**RE: Independence Square
Project 1005517 18DRB-70021**

The following are the DRB comments we received from the original hearing on February 14th along with our response in bold print for revision clarification.

NORTH
A1 **SITE PLAN**
1" = 40'-0"
0 20' 40' 80'

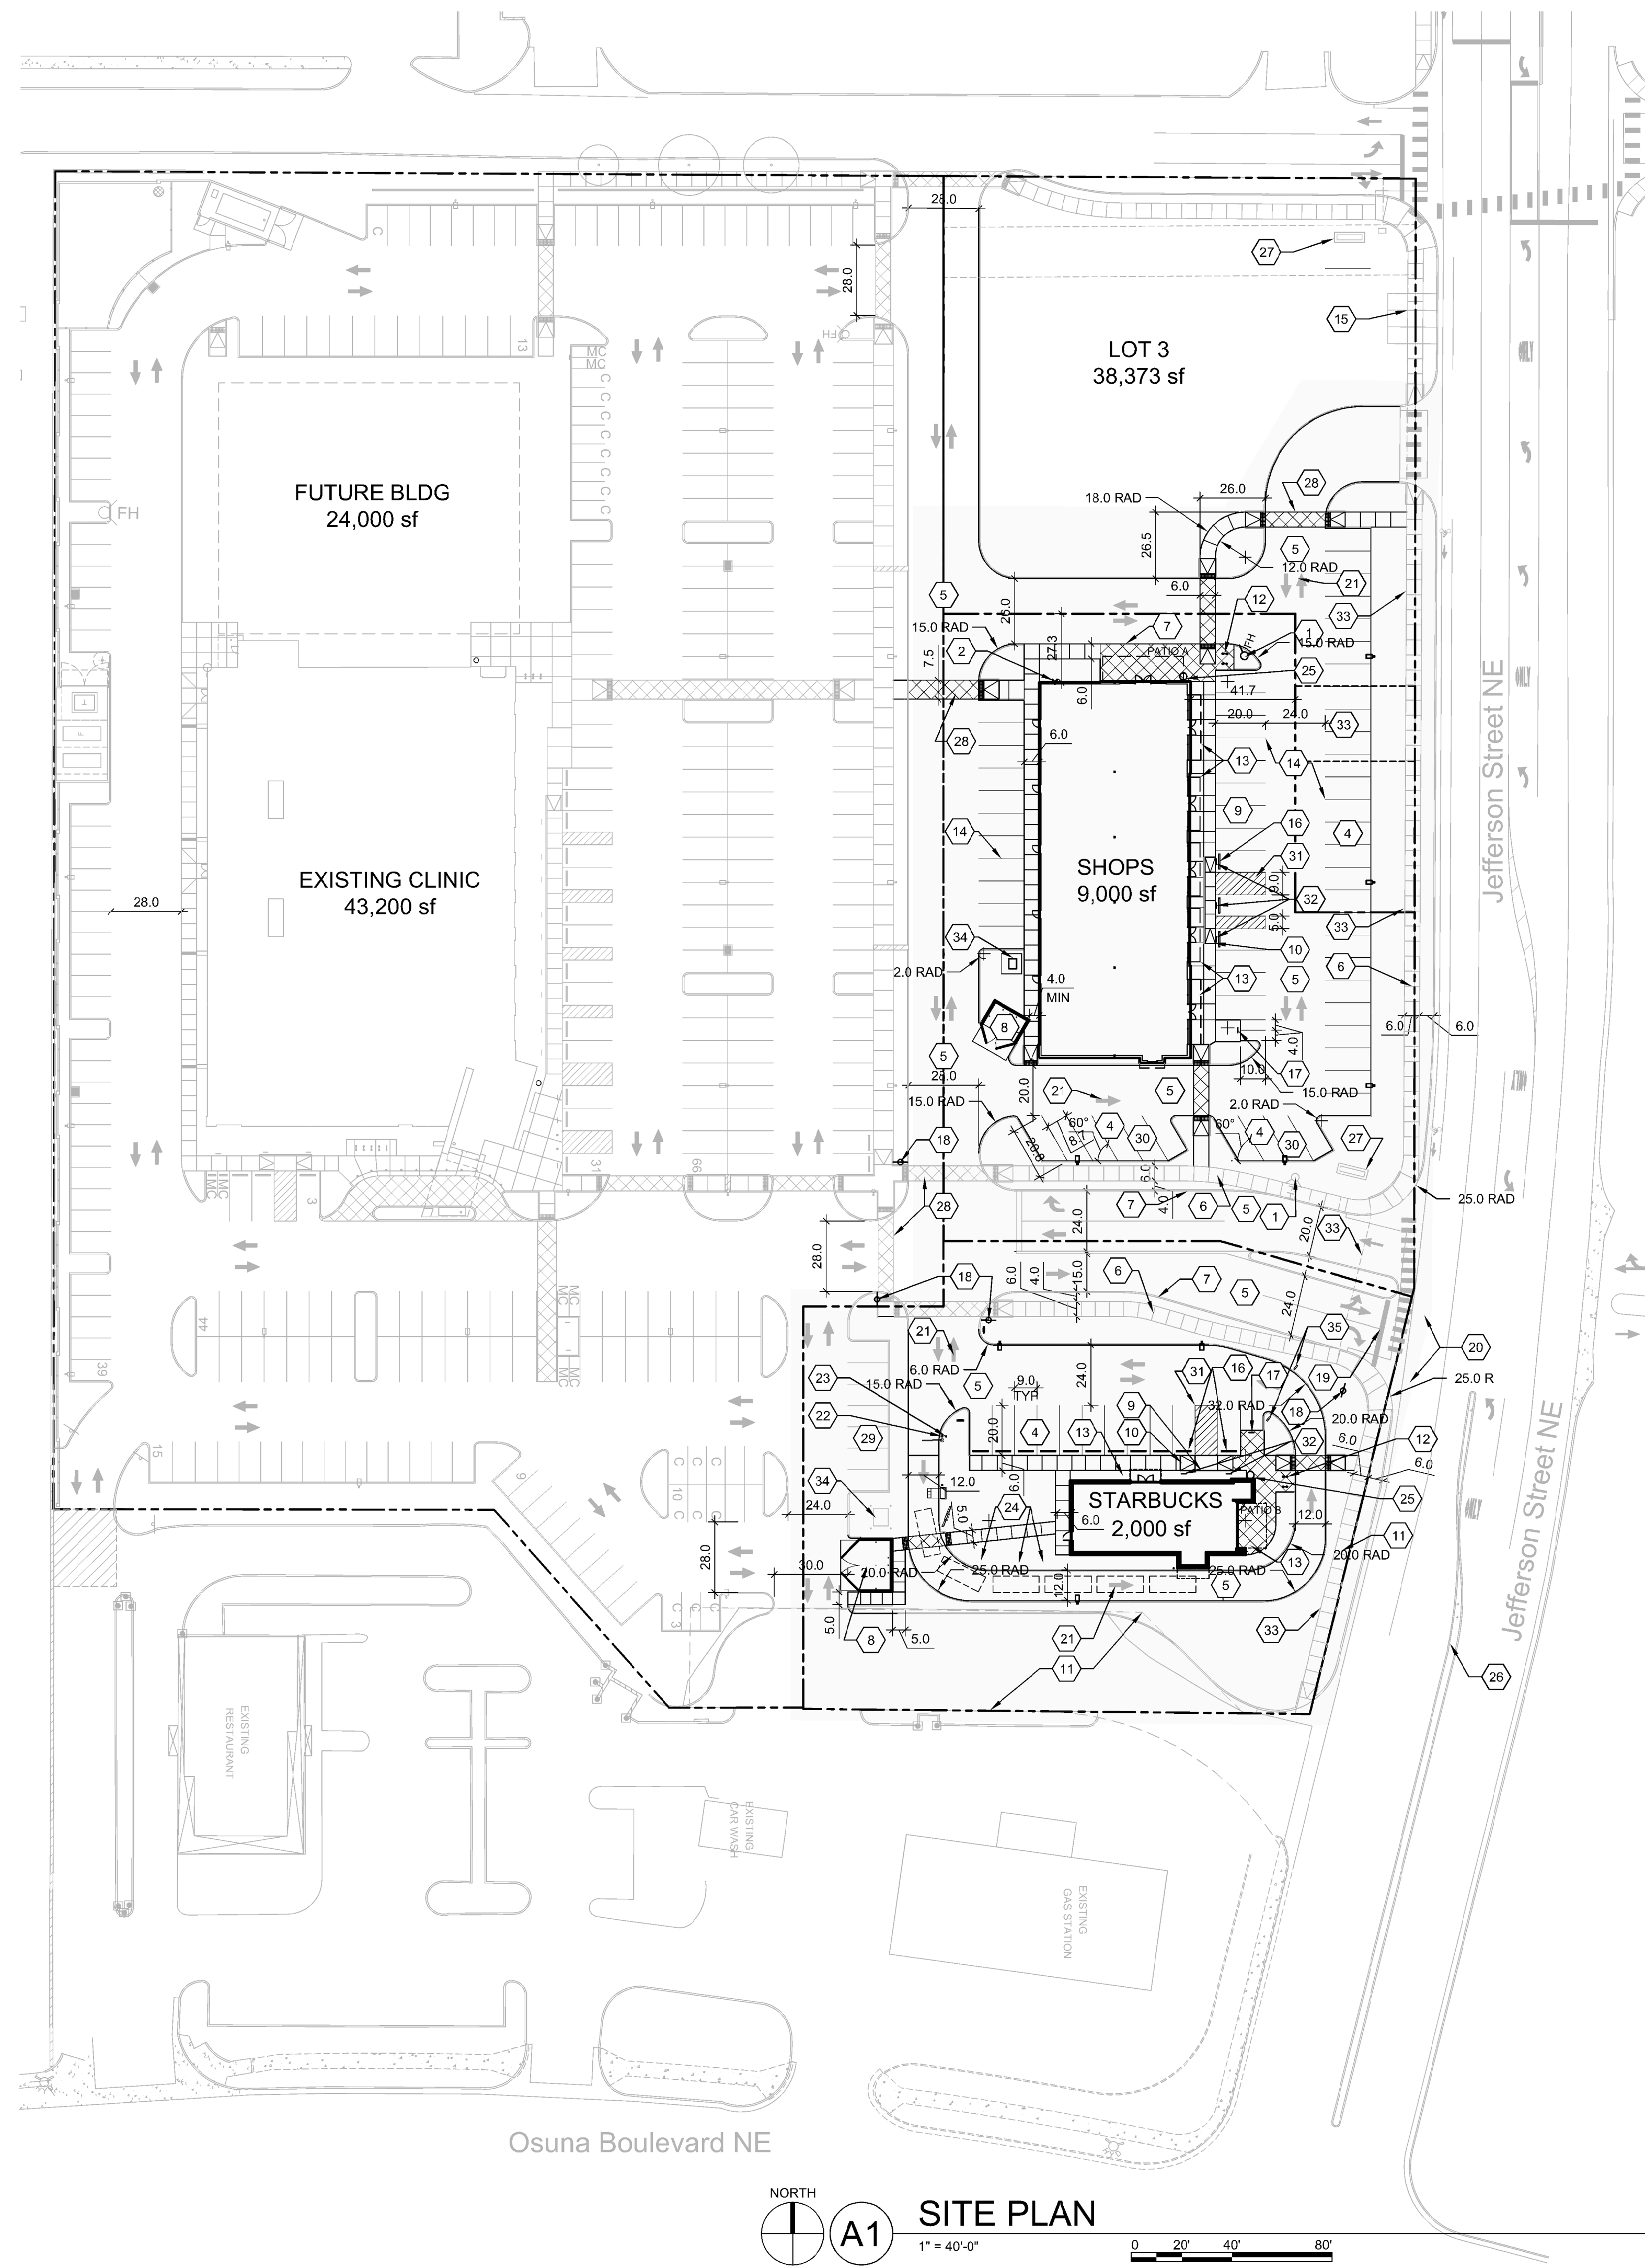
3. The SPS design standards state light fixtures shall be located on the SPBP. Symbols for lights are on the proposed plan sheet AS101 and noted as 12' max height, but there are details for both 12' and 26' lights on sheet ASS01. Please be clear as to which light type and height are shown on the site plan and in which locations.
Light pole height maximum required note has been changed to 26'-0".

SITE PLAN

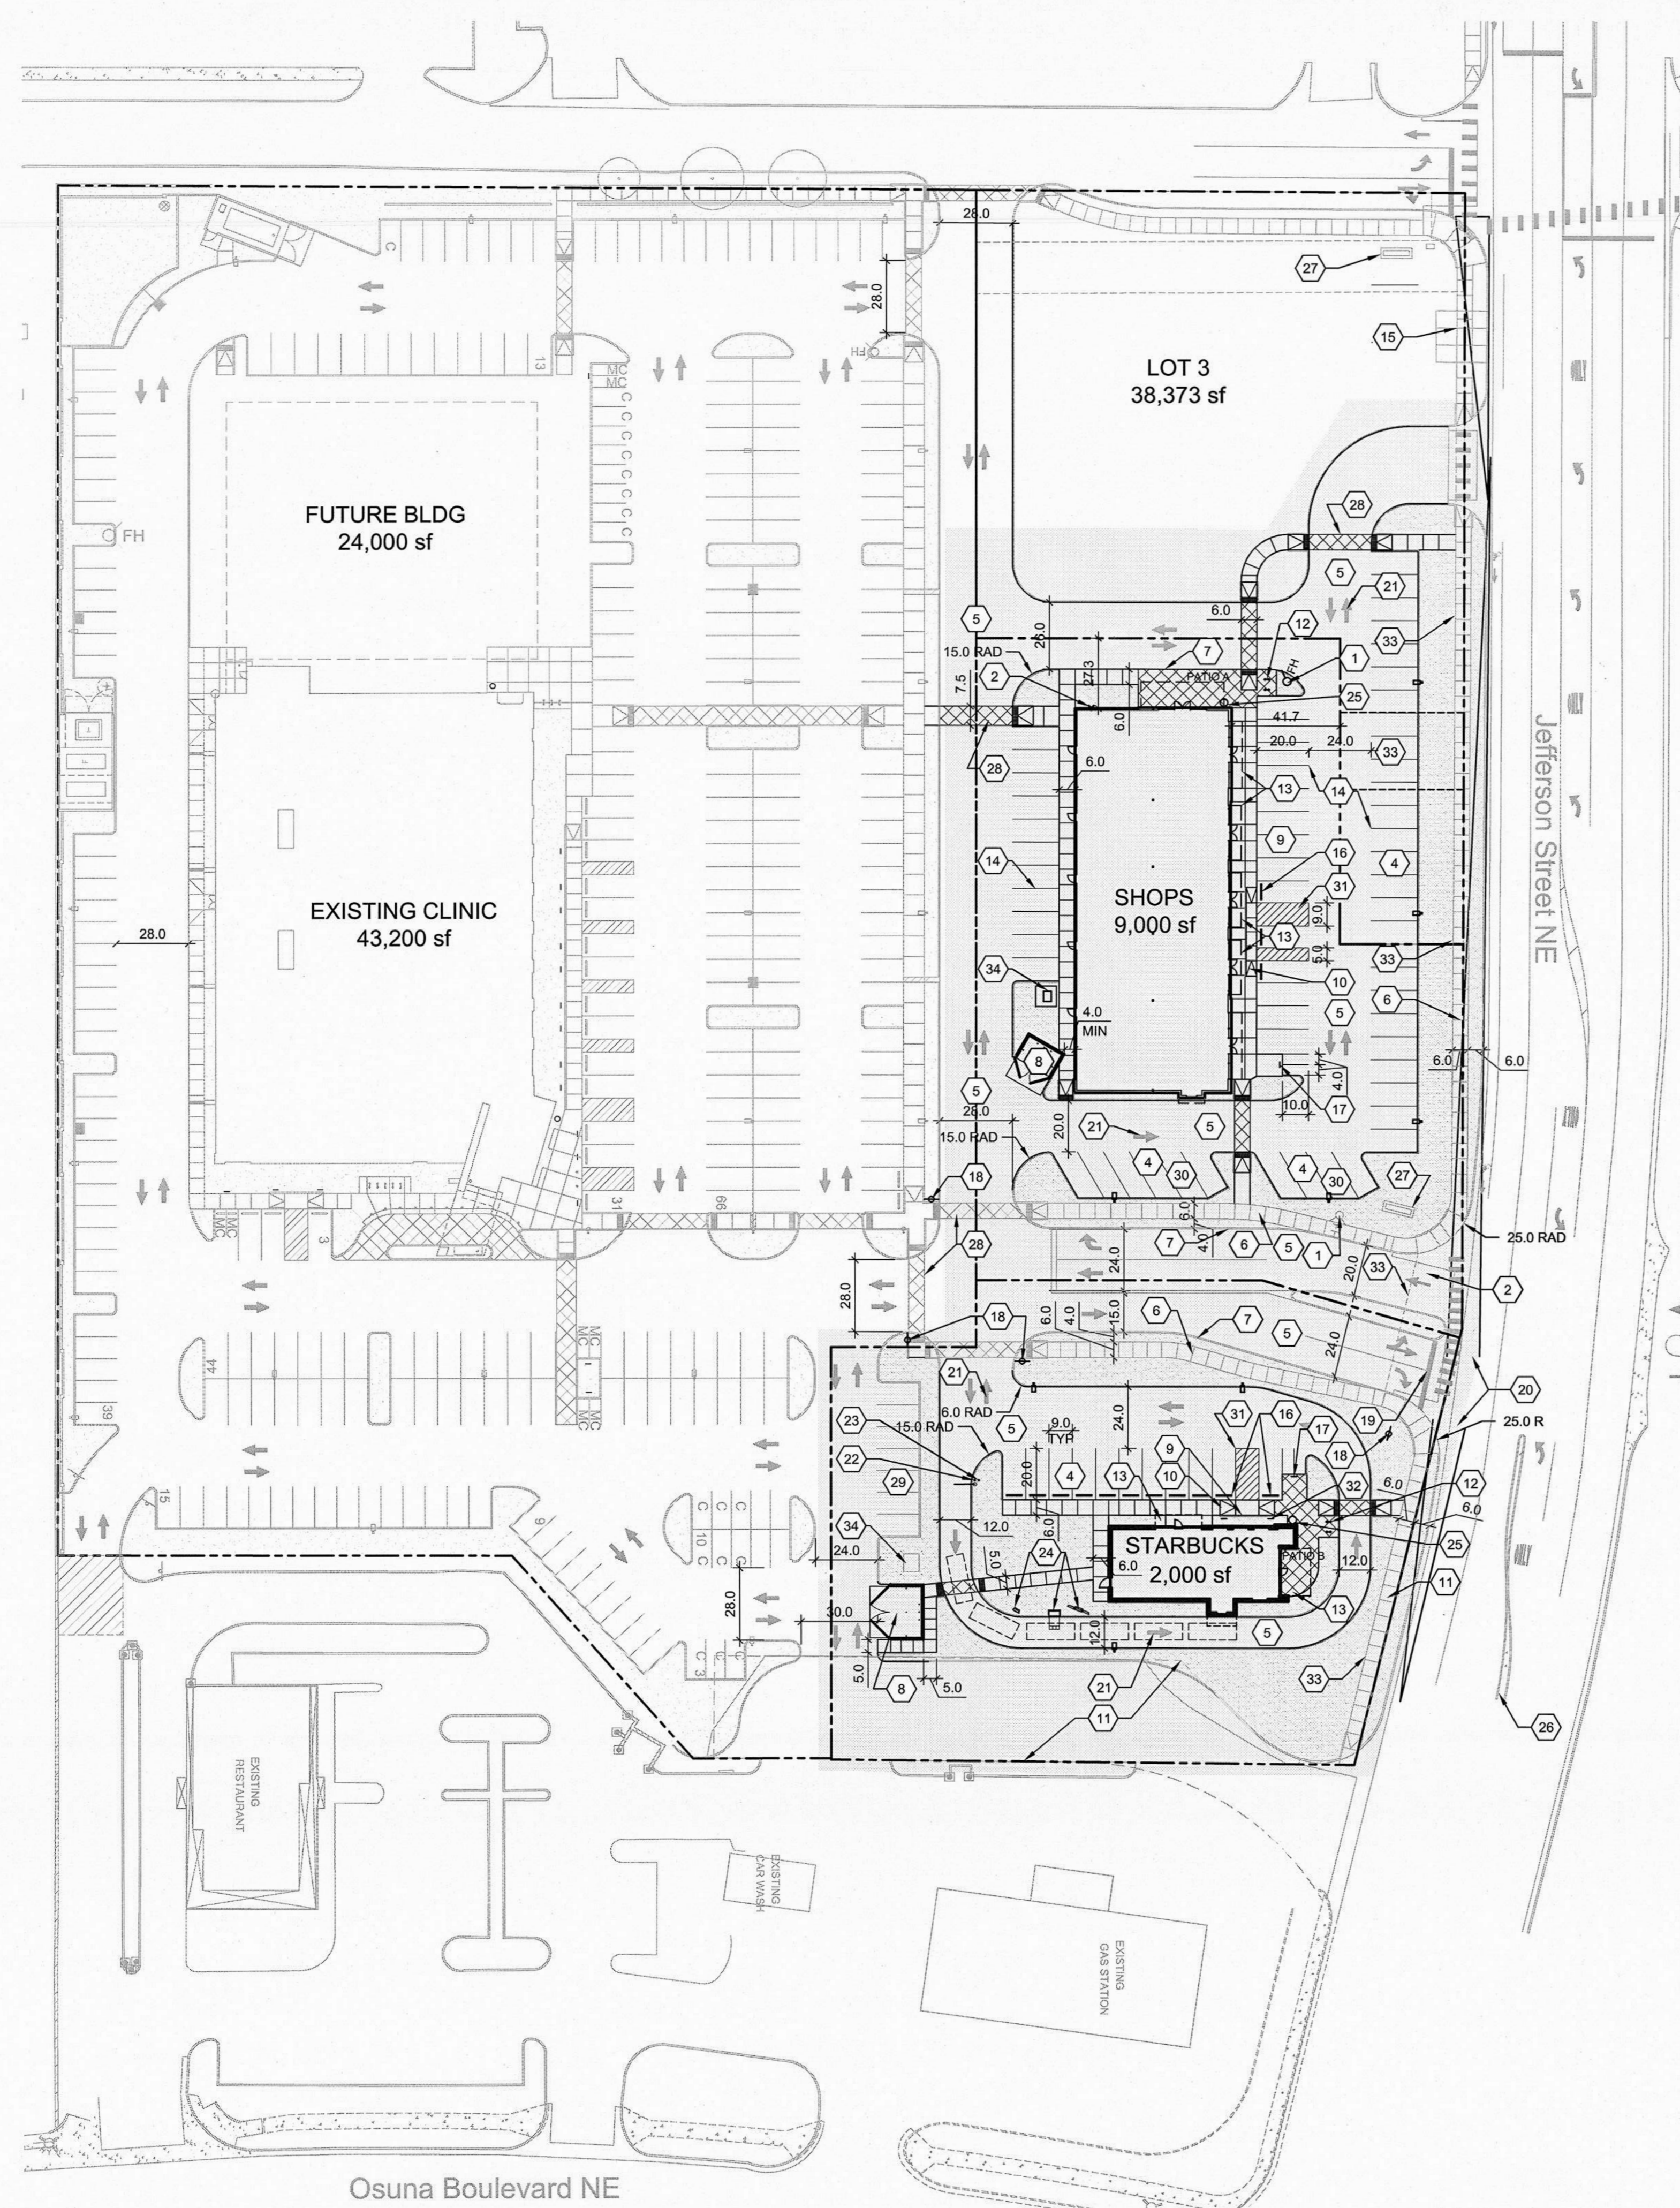
1. General note #4 on sheet AS101 has a typo for the word 'standards'.
Spelling has been corrected for the word 'standards'.
2. At the primary entry drive shared between the two subject lots, there is a keynote #2 that appears misplaced.
Key note 2 has been removed from this area.

5. Required parking shall be provided for each use on their own lot. Breaking out each lot in the calculations may be helpful. The Shops building requires 45 of the total 55 spaces, but only 44 are provided on that property. Please update as needed: is a transit reduction or shared parking agreement applicable, etc.? Otherwise, perhaps a lot line adjustment to put one more space onto the Shops lot instead of Lot 3?
Parking calculations have been changed to reflect the two separate building requirements. Required parking factors in transit reduction since site is within 300 ft. of an existing bus stop.

7. The shops building appears to have a drive-up window on the south end, but no queuing is indicated. Defer to transportation if there is enough room to allow for proper vehicle movements in that drive aisle.
The window at the Shops building will be utilized as a pick-up window for a potential future tenant.

1. List radii on curves through Starbucks drive-thru.
Radii on Starbucks drive-thru curves have been added to the site plan.
2. Call out signs for ADA parking at all locations.
All ADA parking signs are key noted on site plan.

3. Add "Do Not Enter" sign at exit of Starbucks drive-thru.
"Do Not Enter" signs has been added to Starbucks drive-thru lane egress.
4. Provide dimensions and angles for the angled parking at Shops building.
Dimensions and angles for the Shops angled parking have been added to the site plan.

5. The STOP sign located at the exit between the Shops and Starbuck should be located as close as possible to the eastbound stop bar. It is currently shown too far to be effective.
This stop sign is existing. Please see photo included with revised package showing actual stop sign location as it relates to the traffic lane.

7. The sidewalk located on Lot 3 needs radii and dimensions.
Dimensions and radii for the sidewalk located in lot 3 has been added to site plan.

LANDSCAPE PLAN

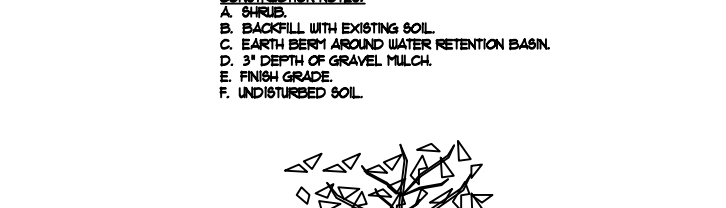
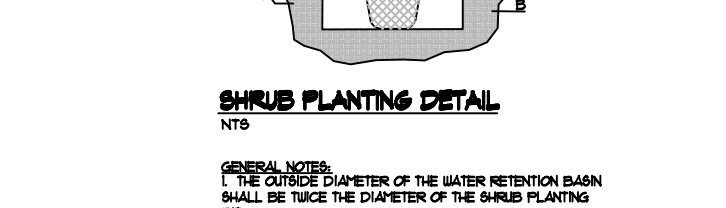
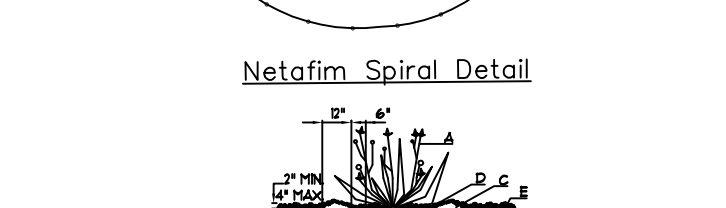
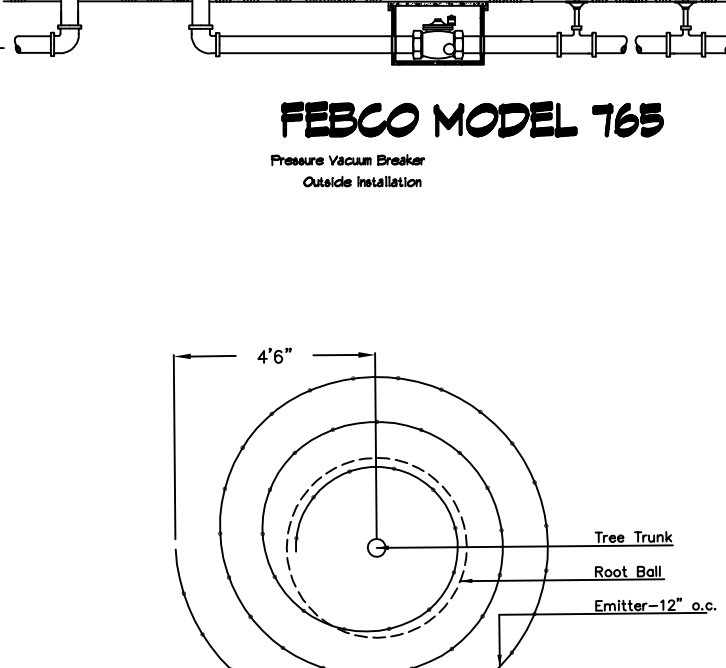
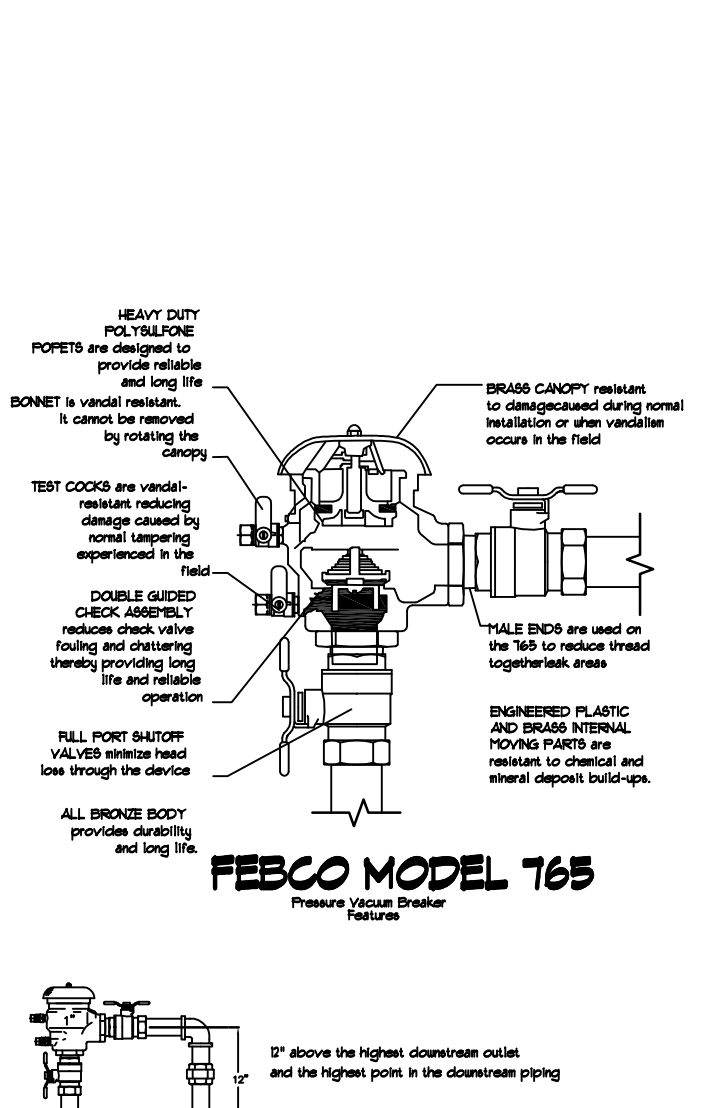
8. The landscape plan does not conform to the SPS required plant palette. Please update.
The SPS required palette is extremely limiting and out of date with current cultivars. All shrubs and trees have been changed to match the approved palette.

9. Lot two landscape calculation includes a decimal place that is hard to read and appears at first glance to be a typo for the total requirement. Please update with the update to chosen species in conformance with the SPS.
Number for landscape area required has been revised on landscape plan.

10. Please show street tree and parking lot tree calculations on the landscape plan.
Street tree calculations currently are located on the plan but have been relocated for better visibility.

11. Evergreen height (Austrian pine is proposed on the landscape plan) per the SPS is 10-foot minimum.
Austrian Pine Height has been changed to 10'.
12. The SPS design standards include a maximum gravel size of 1" but larger are shown on the plan.
Gravel is the required size with the exception of the Starbucks site, there is one small area of oversize cobble accents in the rear of the building that doubles as Storm Water Runoff control and water ponding area.
